Southlands Remediation and Development Project

Project Application (MP 06_0191)

Appendix E: BCA Report

To:	DBL Property	Sent by:	Email
Att:	Mr Jeff Lord	Date:	8 May 2007
From:	Dean Goldsmith	Fax/Email:	jlord@dblproperty.com
Project:	Stage 1 Orica Site, McPherson St, Botany (x 3 Buildings: Warehouse 1/2, Warehouse 3/4 & Warehouse 5/6).	File No:	7323
Re:	Preliminary BCA Assessment	Pages:	3

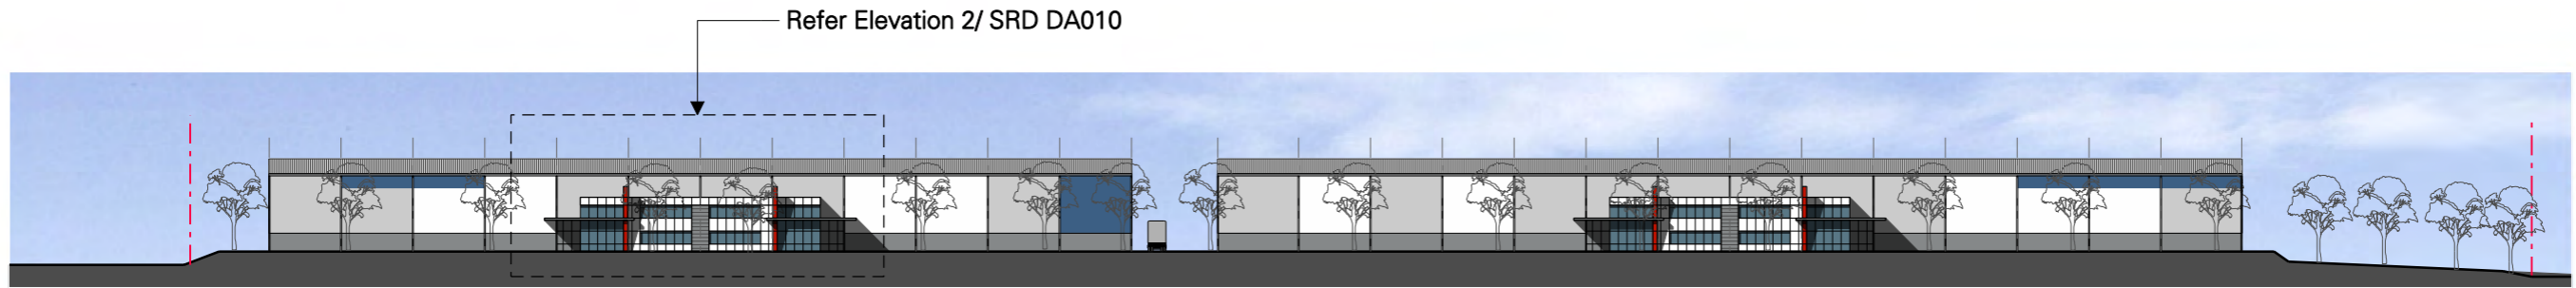
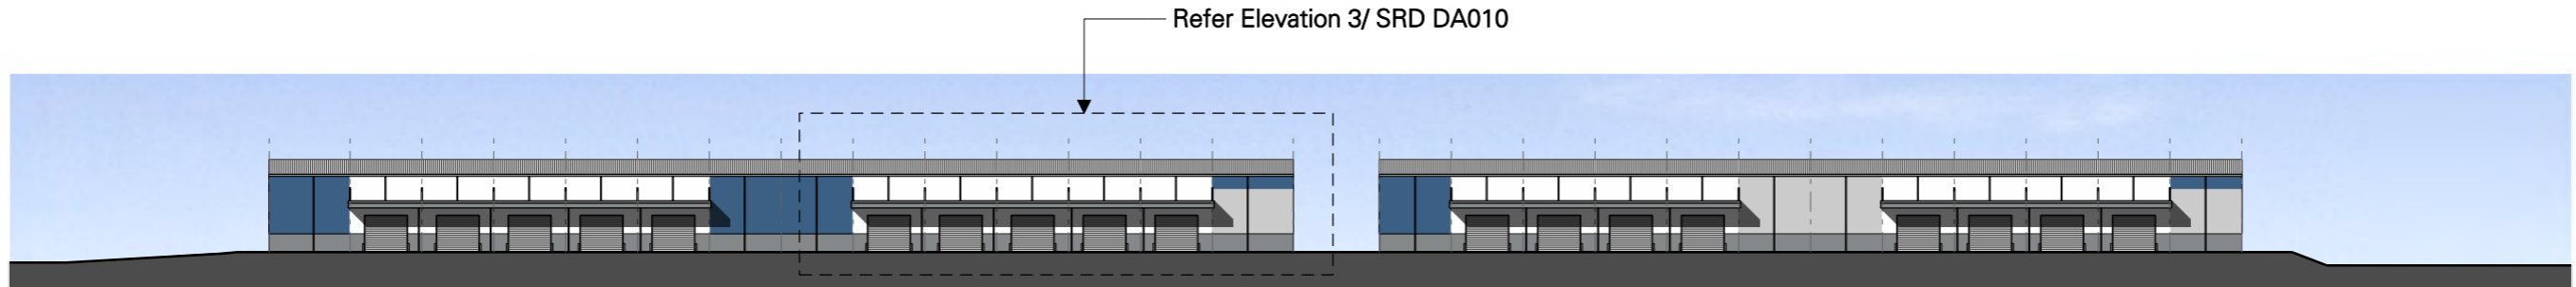
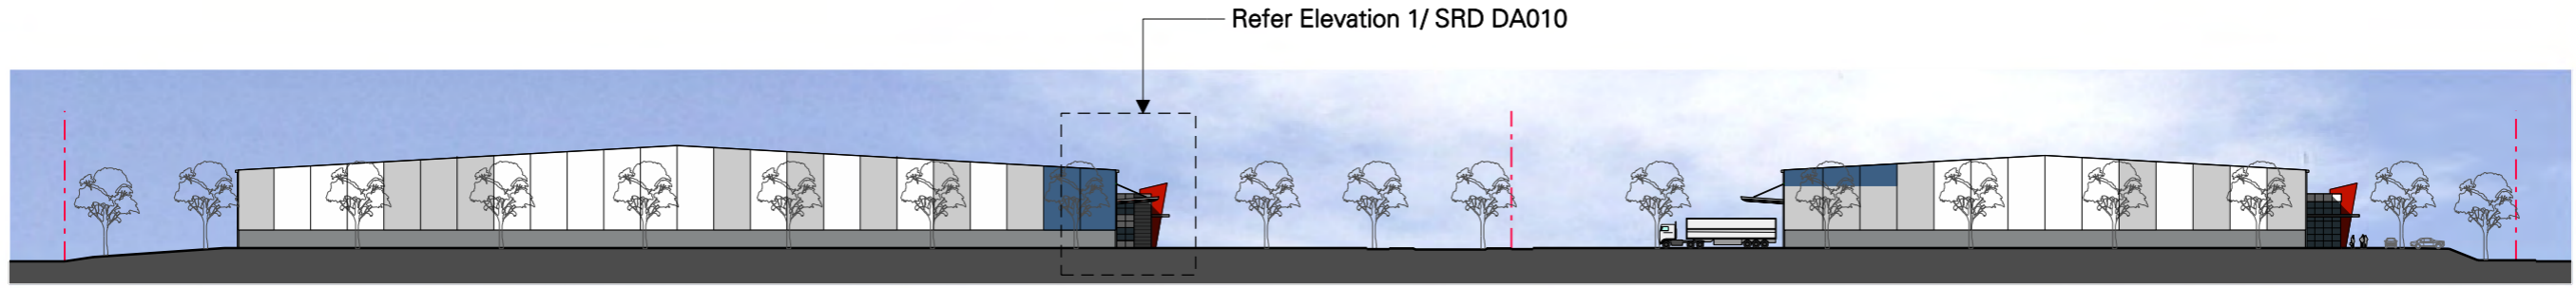
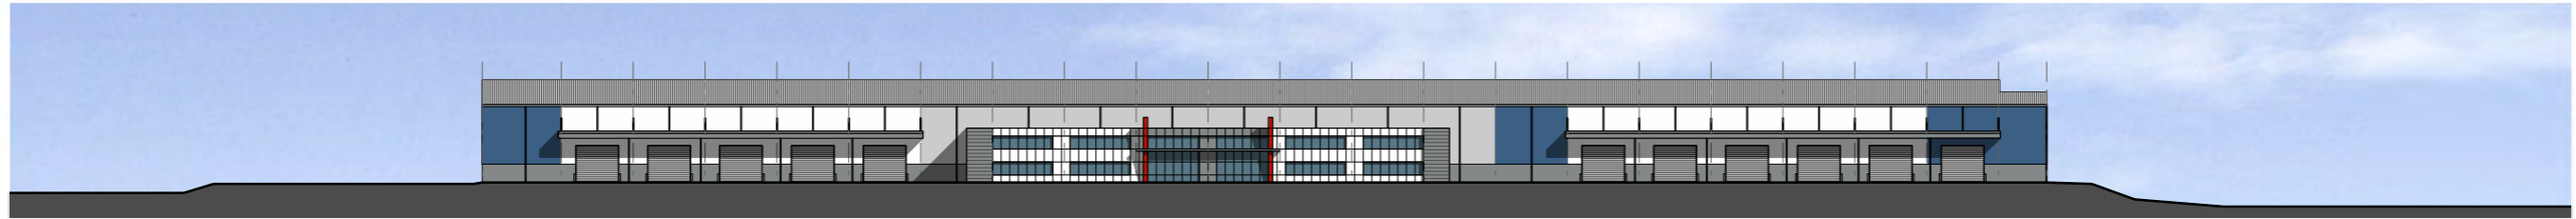
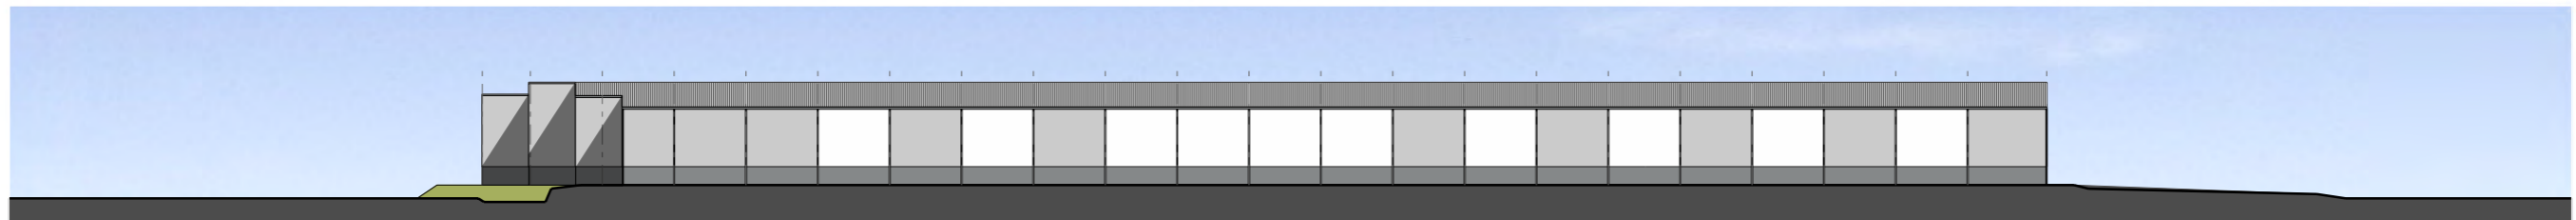
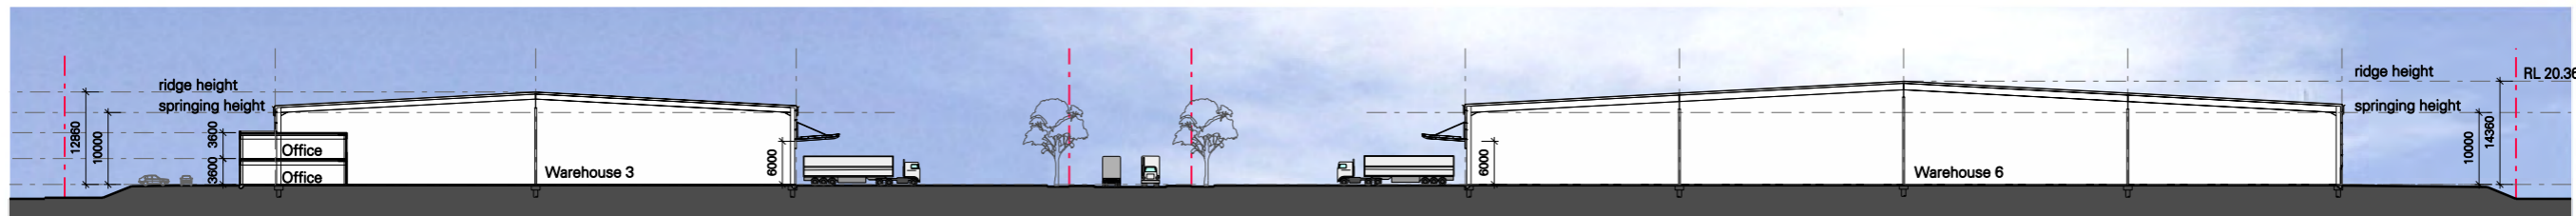
5. BCA cl. C2.4 Requirements for Open Spaces and Vehicular Access: The provisions for open space and vehicular access to all three buildings do not fully comply with the requirements of this clause. This specifically relates to the west side of Warehouse 1/2; to the east side of Warehouse 3/4; and the north and east sides of Warehouse 5/6. In this regard it is understood that you intend to engage a Fire Safety Engineer to address this issue, in order to demonstrate compliance with Performance Requirement CP9. Note: NSW Fire Brigades approval will also be required for the proposed alternative solution.
6. BCA Spec C1.1 Fire Resisting Construction: All three buildings are of Type C Construction and given the proposed setbacks and building configuration, the building elements do not require FRL's under the provisions of Specification C1.1.
